WELWYN HATFIELD BOROUGH COUNCIL – DEVELOPMENT MANAGEMENT
DELEGATED REPORT

APPLICATION No:	S6/2013/0233/FP
APPLICATION Site:	45 Kentish Lane

This application seeks full planning permission for the erection of two storey side and rear extension, single storey rear extension and loft conversion.

PROPOSED REAR ELEVATION

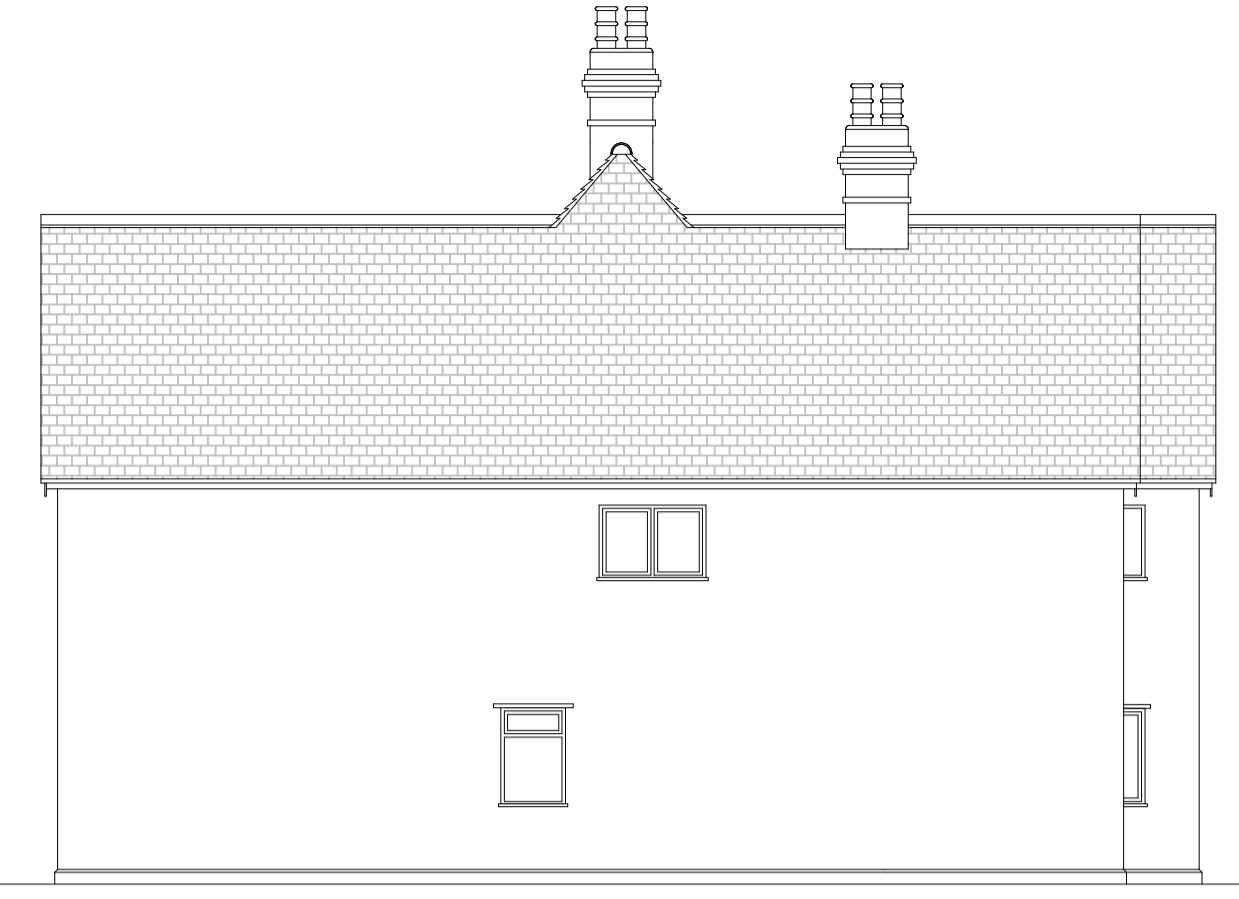
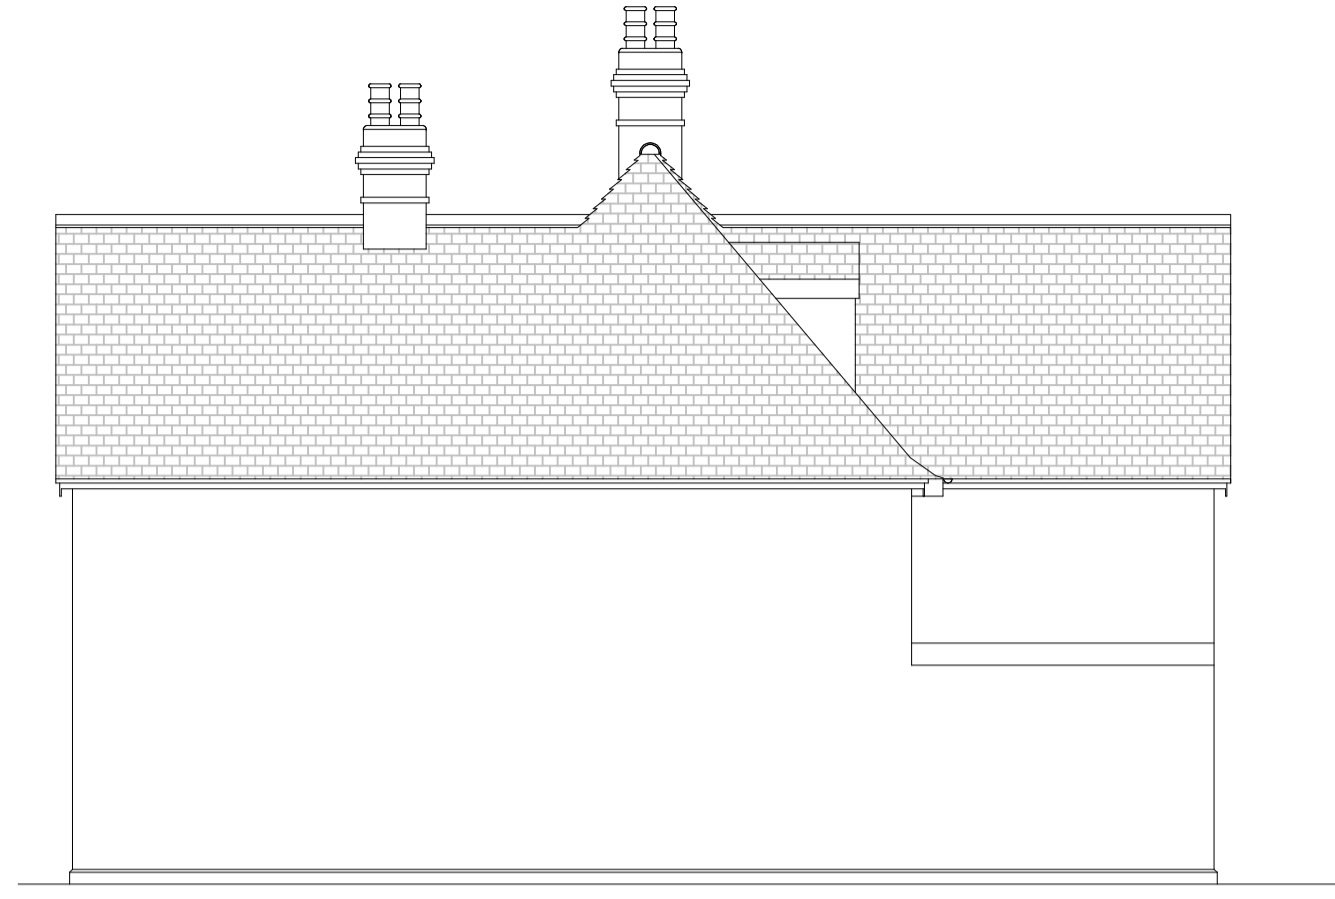
The extended dwelling would be clearly visible from the site frontage and the substantial increase in size and bulk would result in a considerably more massive structure. A large proportion of the increase in bulk would consist of a two storey side extension which would be prominent in views from the highway. In addition, the three dormers to the front elevation would result in additional bulk and mass at a high level. Dormers at the level proposed would give rise to a dwelling that would be instantly recognisable as a three storey property in a streetscene where no other properties appear to exceed two storeys in height. The additional bulk and massing proposed is not considered to be subordinate in size and scale to the existing dwelling and therefore fails to comply with the SPG. The architectural style and materials proposed would not be out of character with the existing dwelling or neighbouring properties, however, the increased scale of the dwelling and the resultant intrusion in to the countryside would fail to maintain the character of the

One representation was received from a neighbouring occupier. The neighbour queried whether or not the flat roof on the north east corner could be used as a balcony. In this respect, no access to the flat roof is shown on either the proposed floorplans or elevations drawings. The use of the flat roof as a balcony would require full planning permission which would be the subject of a separate planning application.

PROPOSED GROUND FLOOR PLAN

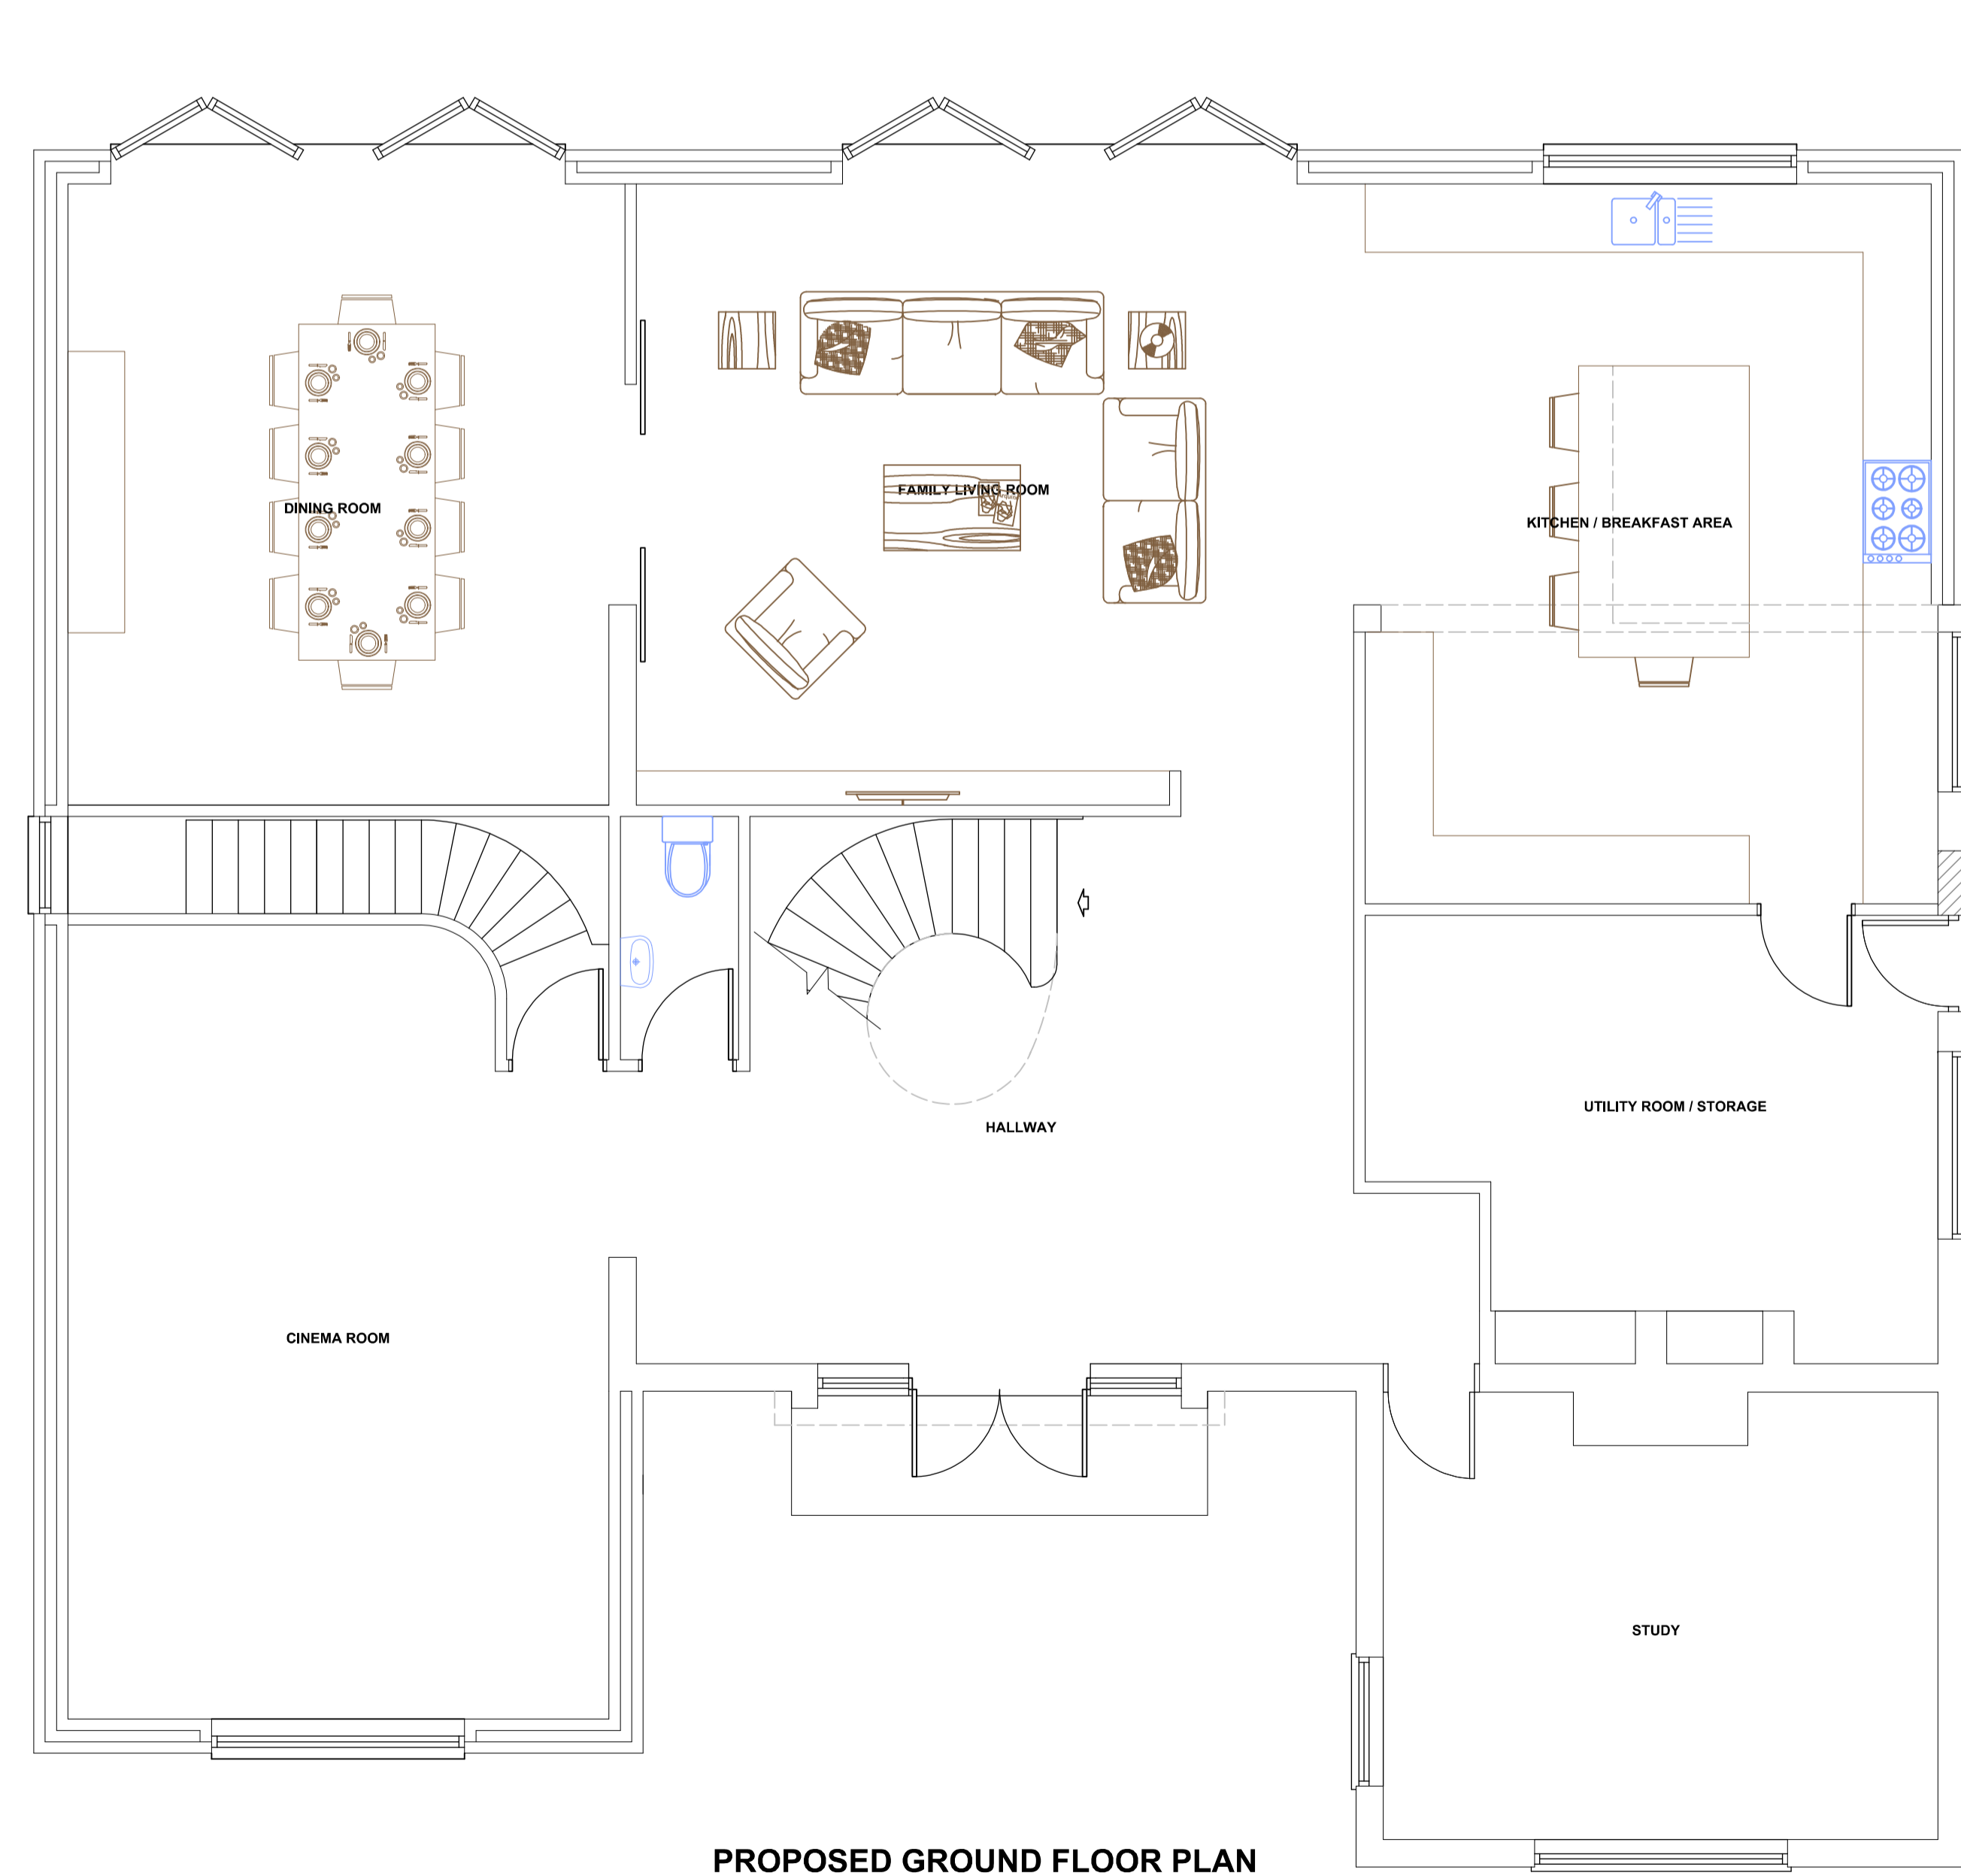
It was also noted that the plans show two windows and a door on the north east wall at ground floor level which are not shown on the elevation drawing. The door and one window would serve the proposed utility/storage room whilst the second windows would serve the kitchen/breakfast area. These windows would provide an outlook towards the flank site boundary and the adjacent property No.47 Kentish Lane. The boundary in this location is well screened by a shiplap fence approximately 1.8m in height in addition to established planting on the side of No.47. As a result, the proposed door and windows would not significantly impact upon the privacy currently enjoyed by the occupiers of the neighbouring property. The proposal is considered to be acceptable in terms of the likely impact on the amenity of neighbouring occupiers.
